## Inspector's Report

### ABP-322098-25

<b>Development</b>	Construction of an Anaerobic Digestion facility along with all associated site works.
<b>Location</b>	Country Crest, Collinstown, Lusk, Co. Dublin
<b>Planning Authority</b>	Fingal County Council
<b>Planning Authority Reg. Ref.</b>	F24A/1162E
<b>Applicant(s)</b>	County Crest ULC
<b>Type of Application</b>	Permission
<b>Planning Authority Decision</b>	Refuse Permission
<b>Type of Appeal</b>	First Party vs. Refusal
<b>Appellant(s)</b>	County Crest ULC
<b>Observer(s)</b>	<ol style="list-style-type: none"><li>1. Peter Foley</li><li>2. Miriam &amp; John McLoughlin</li><li>3. Roisin &amp; Martin Murphy</li><li>4. An Taisce</li><li>5. Ray McDonnell</li><li>6. David Mulcahy &amp; Others</li></ol>

Drawn By	KeB	Scale	AS SHOWN
Checked By	EY	Date	04 Dec '24
Drg.No.	22221/1152	Rev.	A

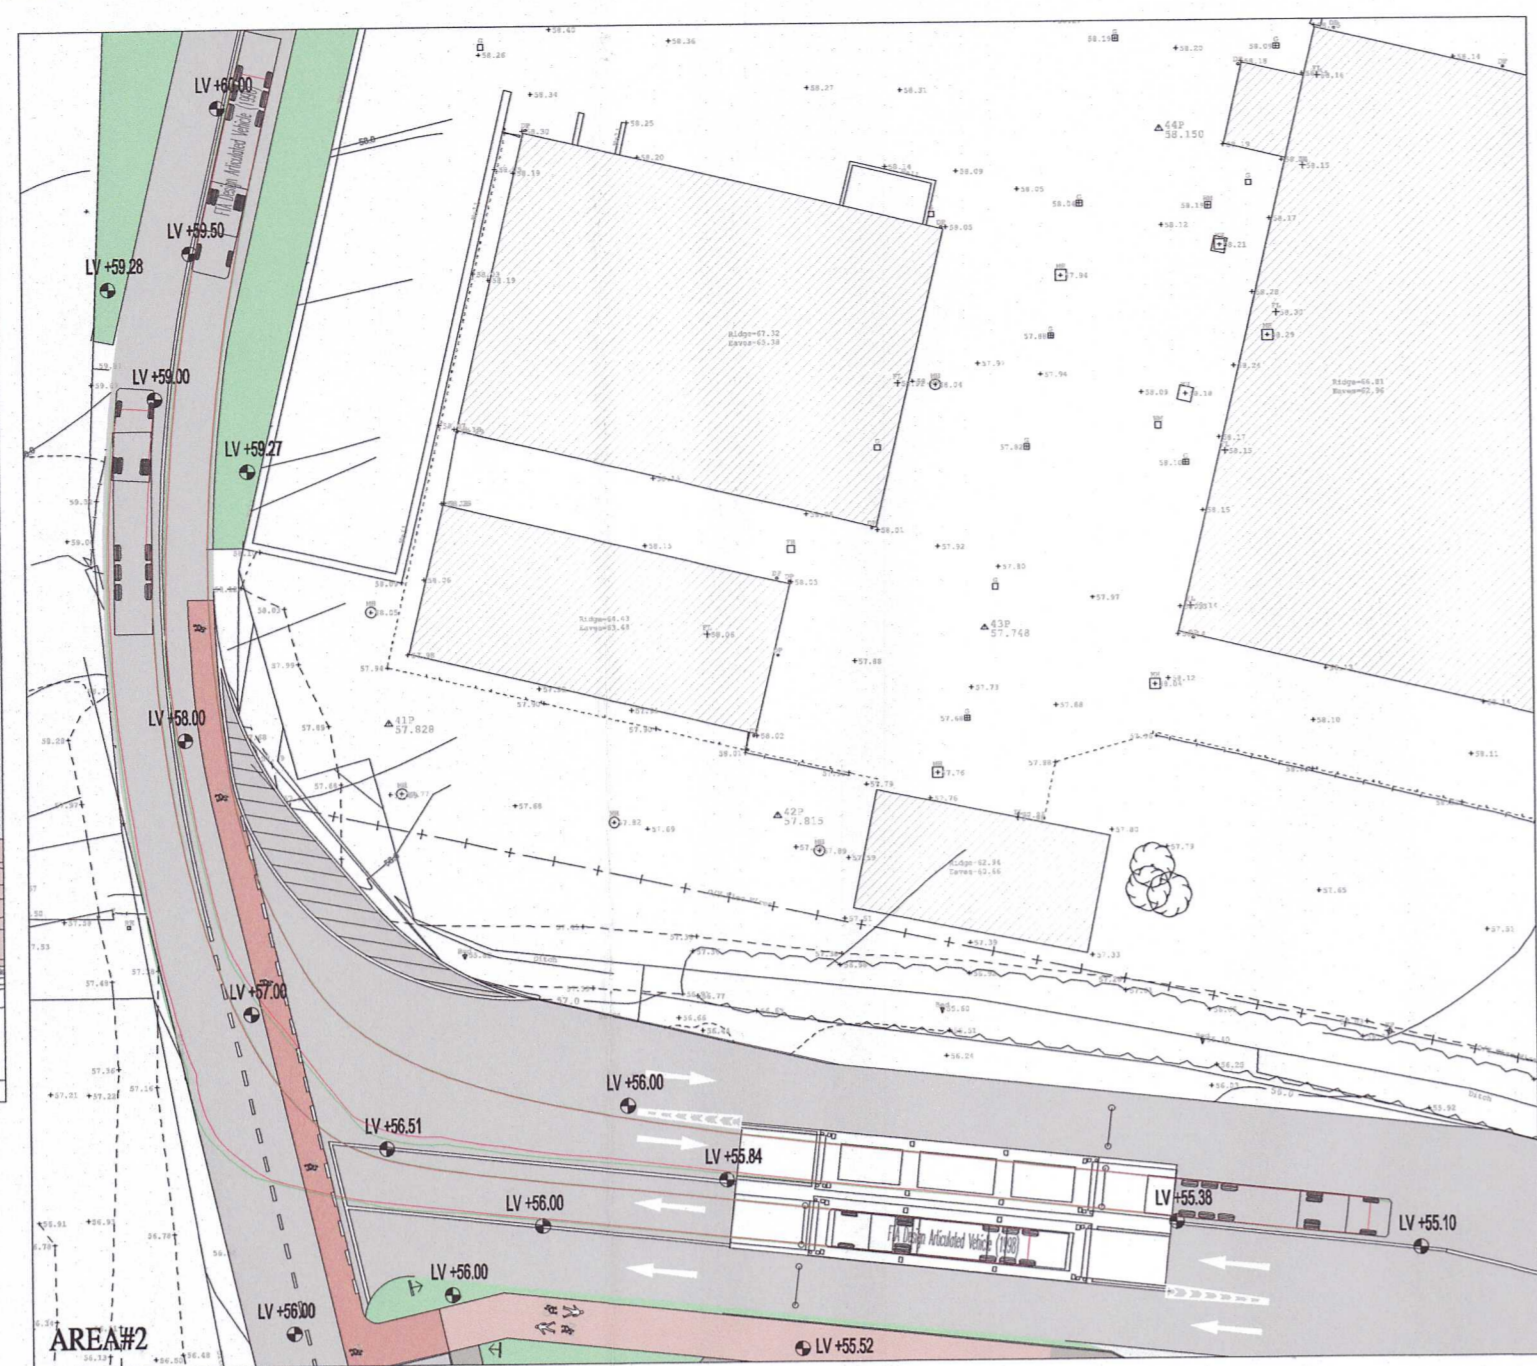
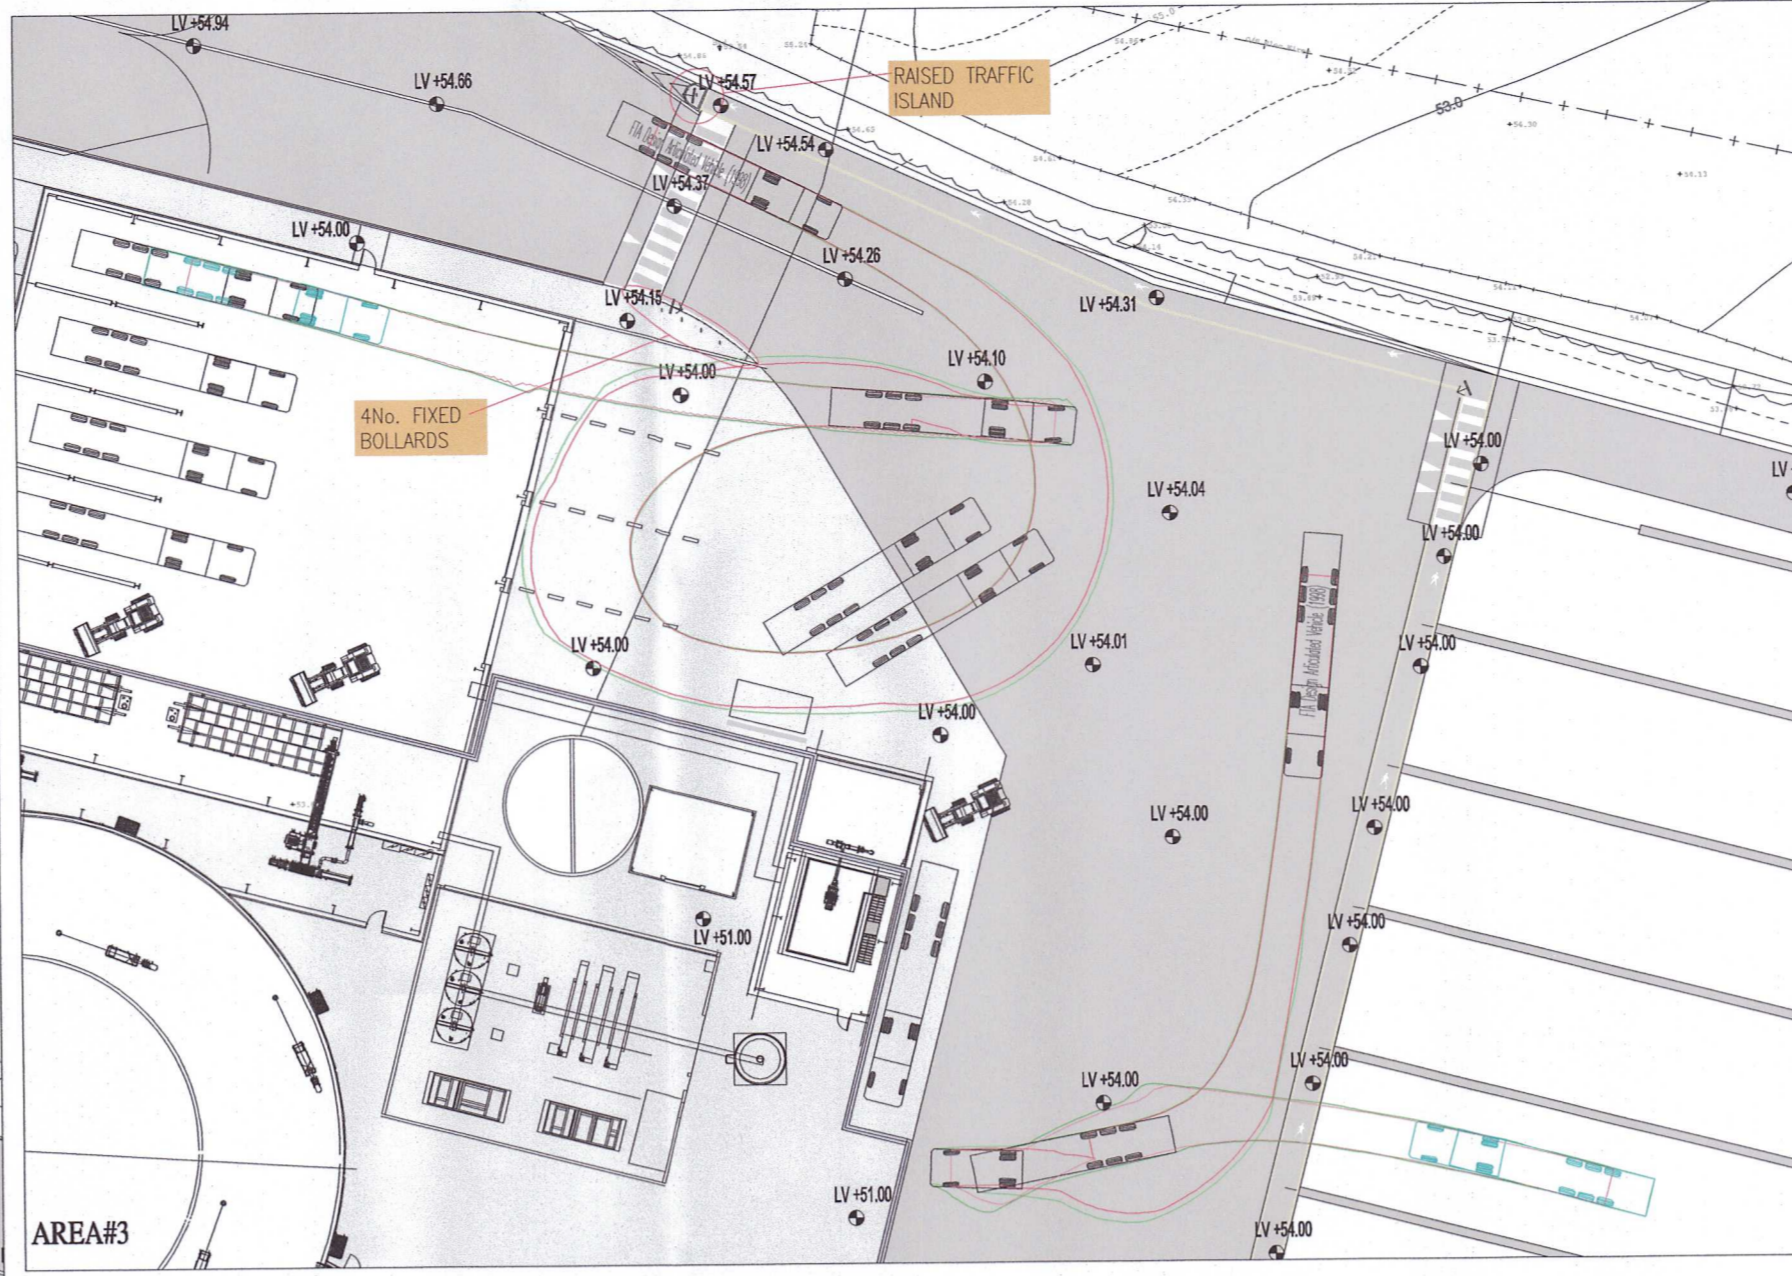
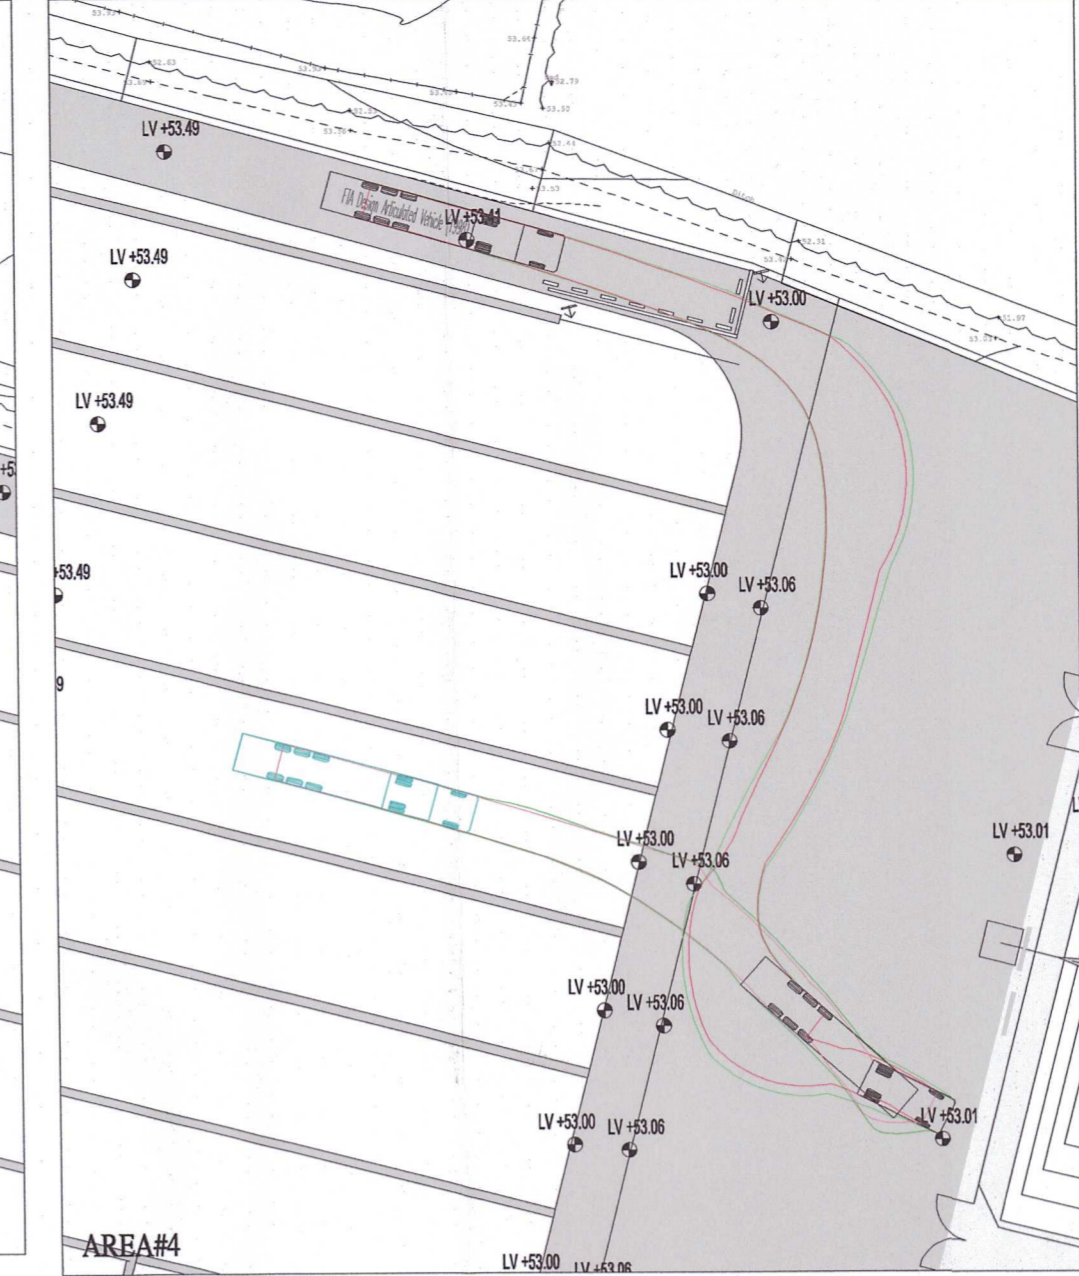
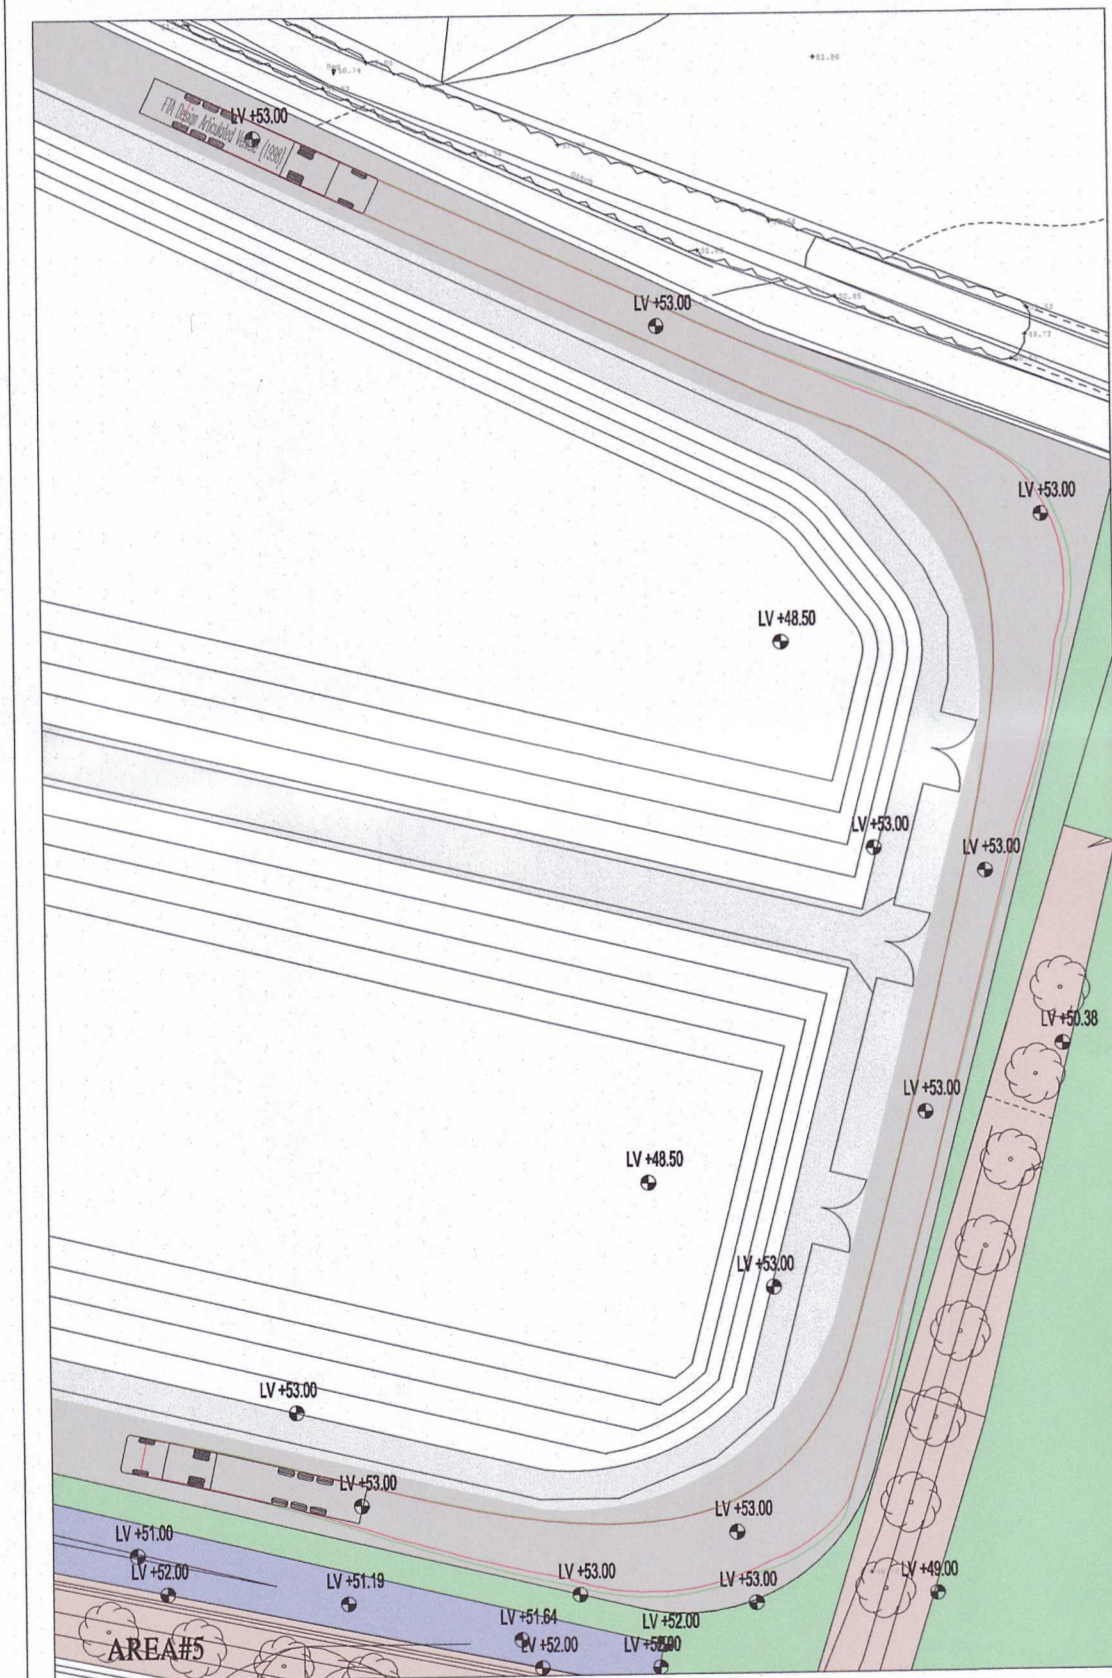
- No standalone Transport Assessment was submitted. Sections 4.4.5 and 11.3.6 of the EIAR deal with traffic impacts and have been reviewed by the FCC Transportation Planning section (as follows).
- There are concerns about the pedestrian movement proposal in terms of layout, width, at-grade level, etc., and that it would not protect vulnerable pedestrians in

close proximity to difficult articulated vehicle movements. The current format is considered a traffic hazard.

- A Road Safety Audit (RSA) has not been provided as is appropriate. The proposal would not protect vulnerable pedestrians in close proximity to difficult articulated vehicle movements. The current format is considered a traffic hazard.
